Copper Chase at Sterling Ranch
Traffic Technical Memorandum
PUDSP-22-002 ¹ 
(LSC #184990)
May 26, 2022

LSC Responses to TIS Redline Comments

Figure 4
School
Pedestrian Routes

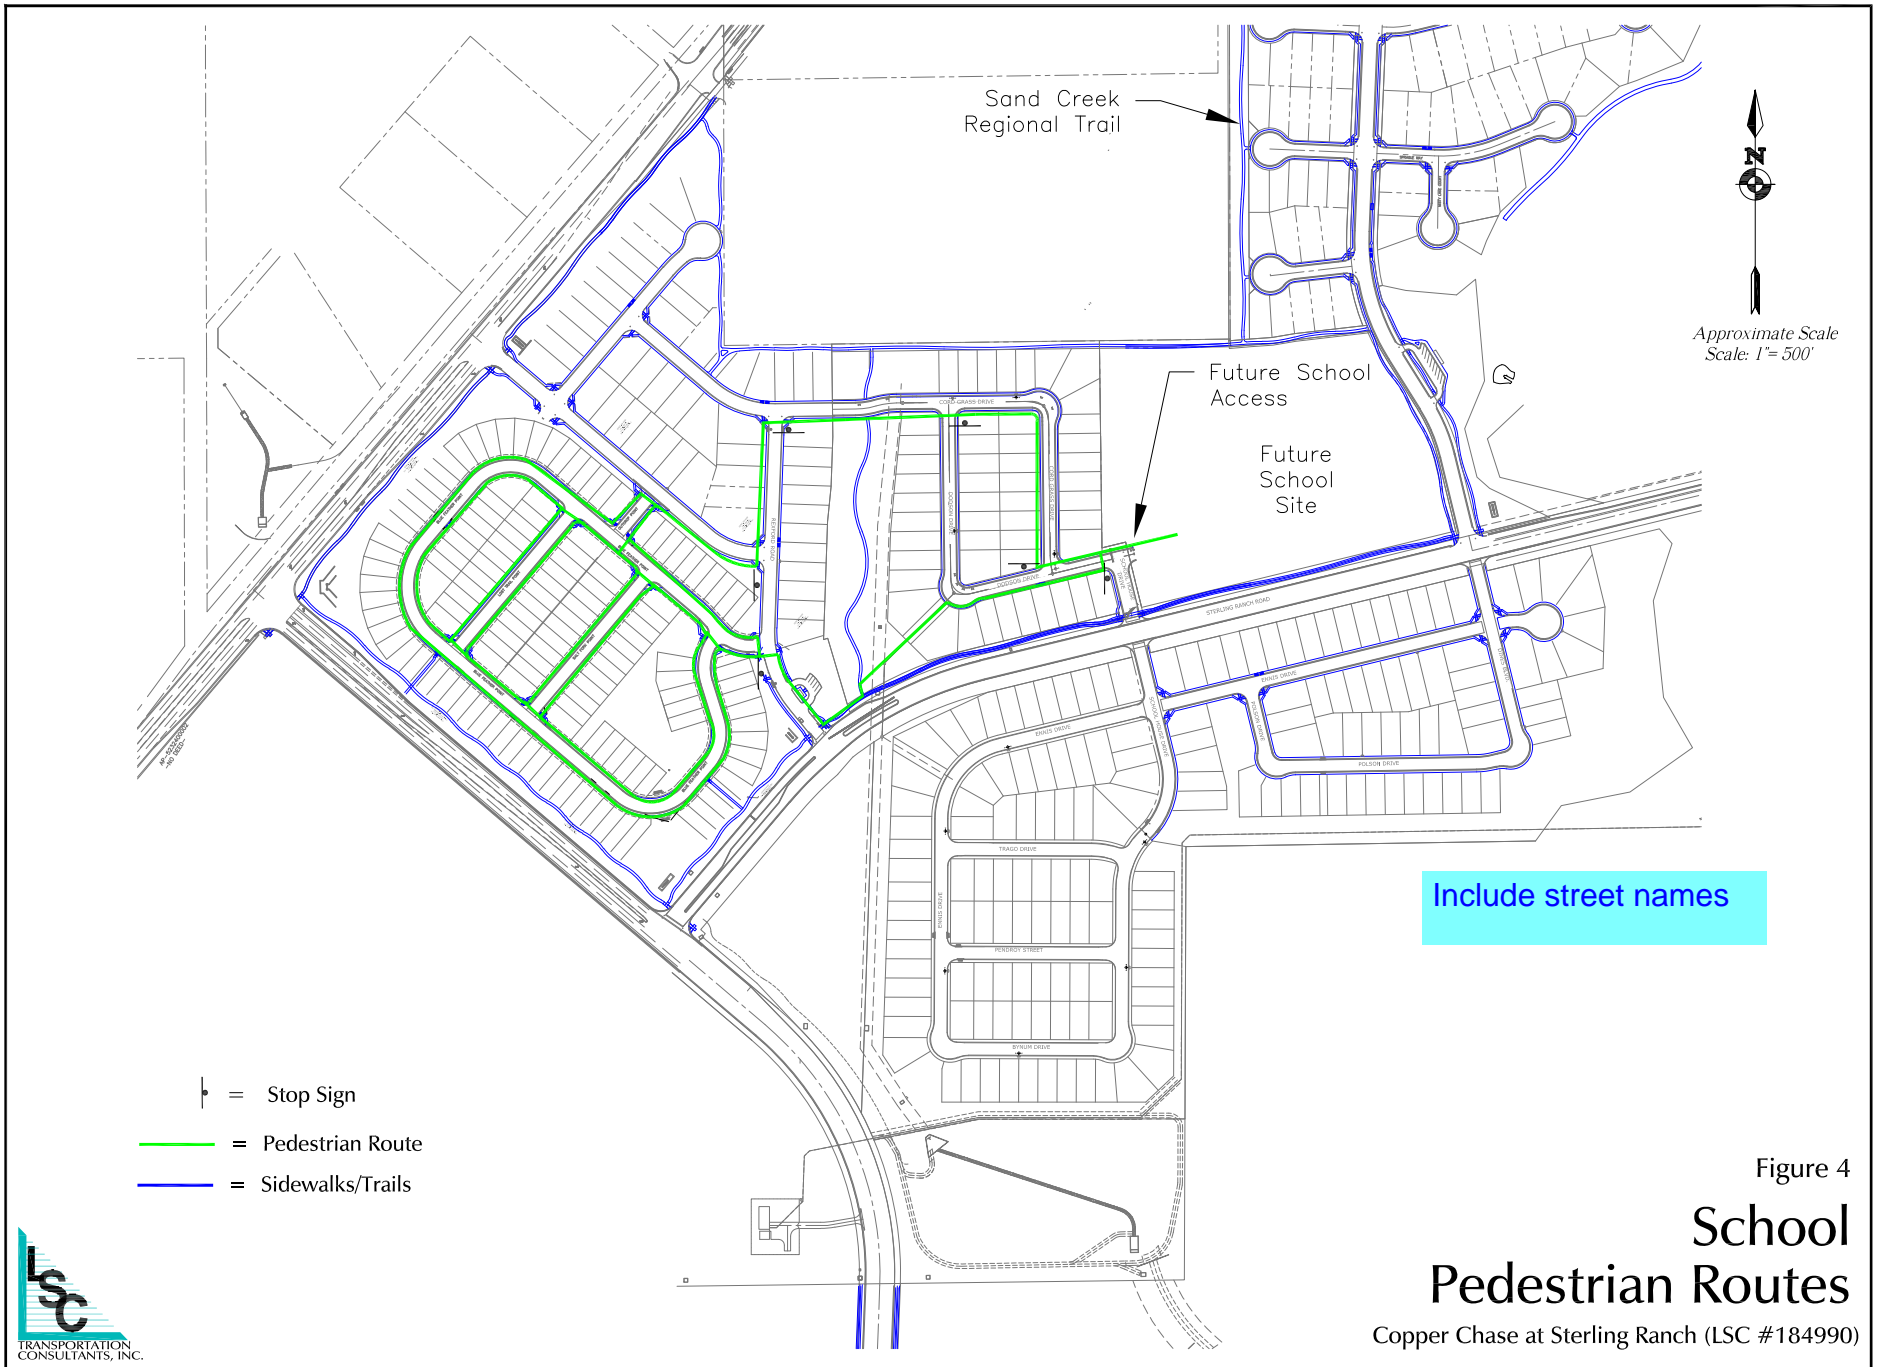
[Include street names](#)

Author: jchodsdon Subject: Sticky Note Date: 4/26/2023 08:35:37
LSC Response: Added as requested. Note: this Figure has been modified the updated TIS
